13 November 2025

TII25-133394

Re: Strategic Infrastructure Development Application for 10 year planning permission for Ballinlee Wind Farm consisting of 17 no. wind turbines, a permanent 110kV substation and ancillary development, County Limerick

ACP case ref. PAX91.323780

Figure 2-4: Proposed Grid Route Connection to existing 220/110kV Killonan Substation

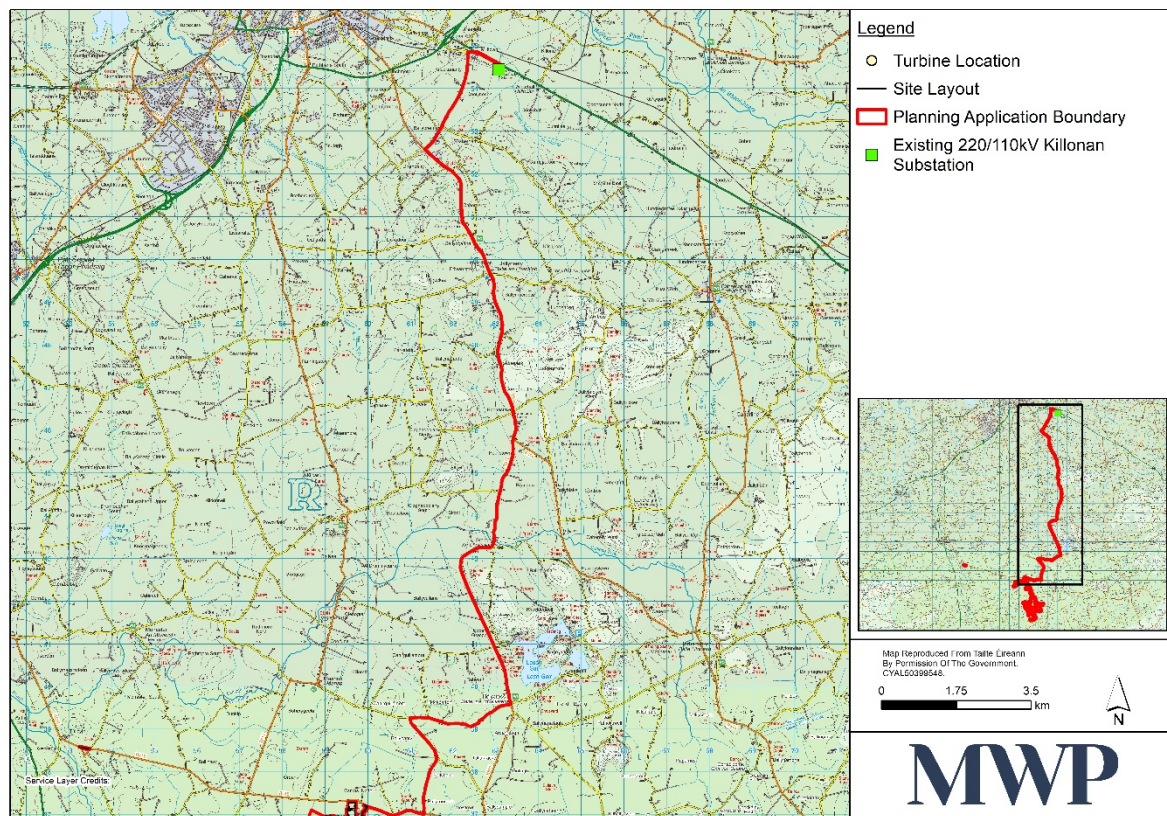
In relation to the specific proposal, the EIAR submitted indicates a proposed 110kV grid connection routing from the subject windfarm site to the Killonan 220/110kV substation via the local and regional road network and a section of the N24, national primary road.

In the context of the Ballinlee Wind Farm grid connection, the first 700 metres of the route runs northwest along the N24 before turning south and continuing along regional and local roads toward the wind farm site. In the first 700m there are three crossings, 1 no. farm underpass and 2 no. box culverts. It is intended that the grid cable will be installed on the south side of the N24 carriageway but within the curtilage of the N24, the exact position of the cable and interface with the road curtilage will be agreed with TII and EirGrid’.

TII considers that the statement included in Section 2.2.1 of Appendix 2D is misleading to state that TII previously refused permission to install high voltage cables within their motorway and national primary roadways without the foregoing context and without acknowledging that TII is not a planning authority with decision making powers in that regard and, additionally, is often not the road authority. This statement requires clarification in TII’s opinion.

In terms of identifying the ‘optimal solution’ for grid routing, TII notes proposals to HDD a grid route connection along the N24, national road, including three crossings and the provision of a joint bay within the road reservation.

In considering the proposed grid connection routing TII requests that the Commission assesses the proposed grid connection routing to determine that the ‘optimal solution’ results, having regard to the foregoing considerations and the potential availability of alternatives with significantly reduced impact to the road network, including the strategic national road network, in the area.

Figure 2-5: Proposed Turbine Delivery Route.

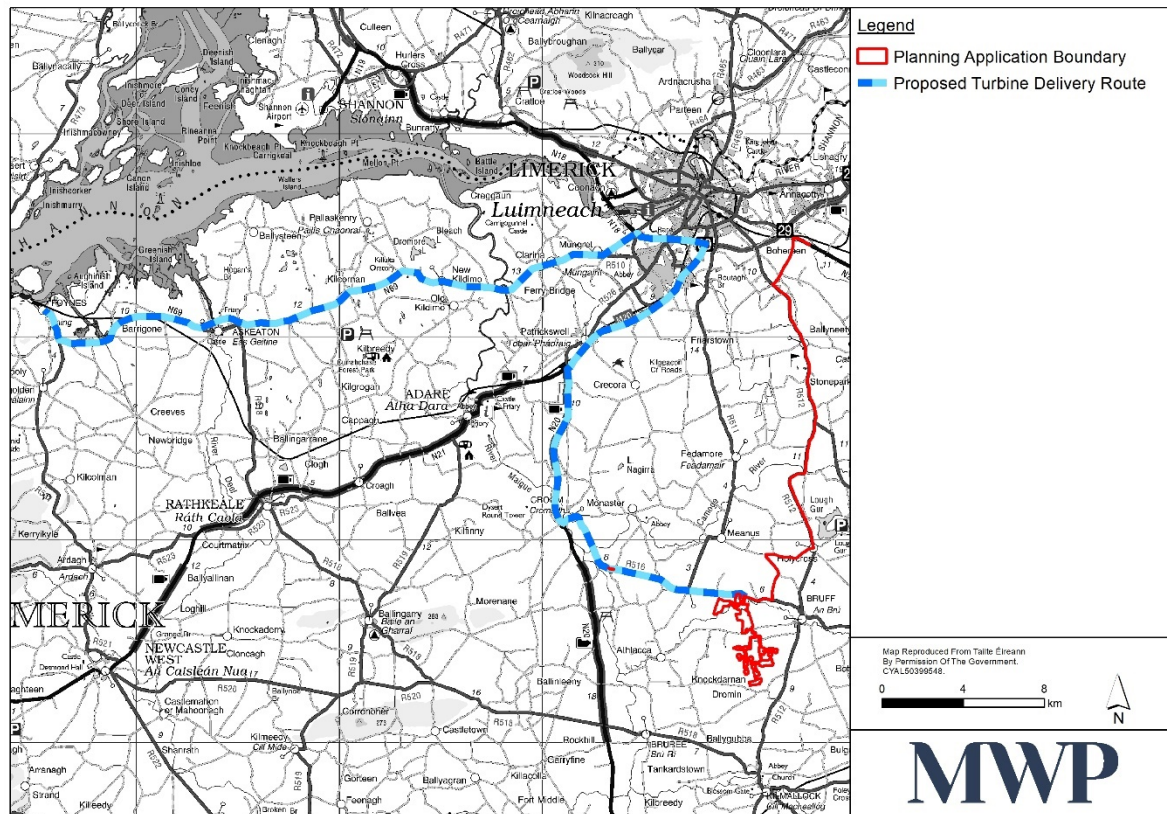
Section 16.4.6 of the EIA outlines 'Delivery Vehicle Routes' with Section 2.3.6 identifying the 'Turbine Delivery Route' and Appendix 2C containing the 'Turbine Delivery Route Report' with Foynes identified as the port of entry. Haul routing includes utilising the N69, N18, M20 and N20, national roads. Minor and temporary works are proposed to facilitate turbine component delivery to site.

In the first instance, the national road network is managed by a combination of PPP Concessions, Motorway Maintenance and Renewal Contracts (MMaRC) and local road authorities. The applicant/developer should consult with all PPP Companies, MMaRC Contractors and road authorities over which the haul routes traverse to ascertain any operational requirements such as delivery timetabling, etc. and to ensure that the strategic function of the national road network is maintained.

TII requests referral of all proposals agreed between the road authorities, PPP Concessions and MMaRC Companies and the applicant impacting on national roads. Mitigation measures identified by the applicant should be included as conditions in any decision to grant permission. Where temporary works within any MMaRC Contract Boundary are required to facilitate the transport of any abnormal loads to site, the applicant/developer shall contact thirdpartyworks@tii.ie in advance, as a works specific Deed of Indemnity will be needed by TII before the works can take place.

In the interests of clarification, any proposed works to the national road network to facilitate turbine component delivery to site shall comply with TII Publications and shall be subject to Road Safety Audit as appropriate. Works should ensure the ongoing safety for all road users and prior to any development necessary licenses, approvals or agreements with the local road authorities shall be in place.

Any damage caused to the pavement of the existing national road due to the turning movement of abnormal 'length' loads (eg. tearing of the surface course) shall be rectified in accordance with TII Pavement Standards and details in this regard shall be agreed with the Road Authority prior to the commencement of any development on site.
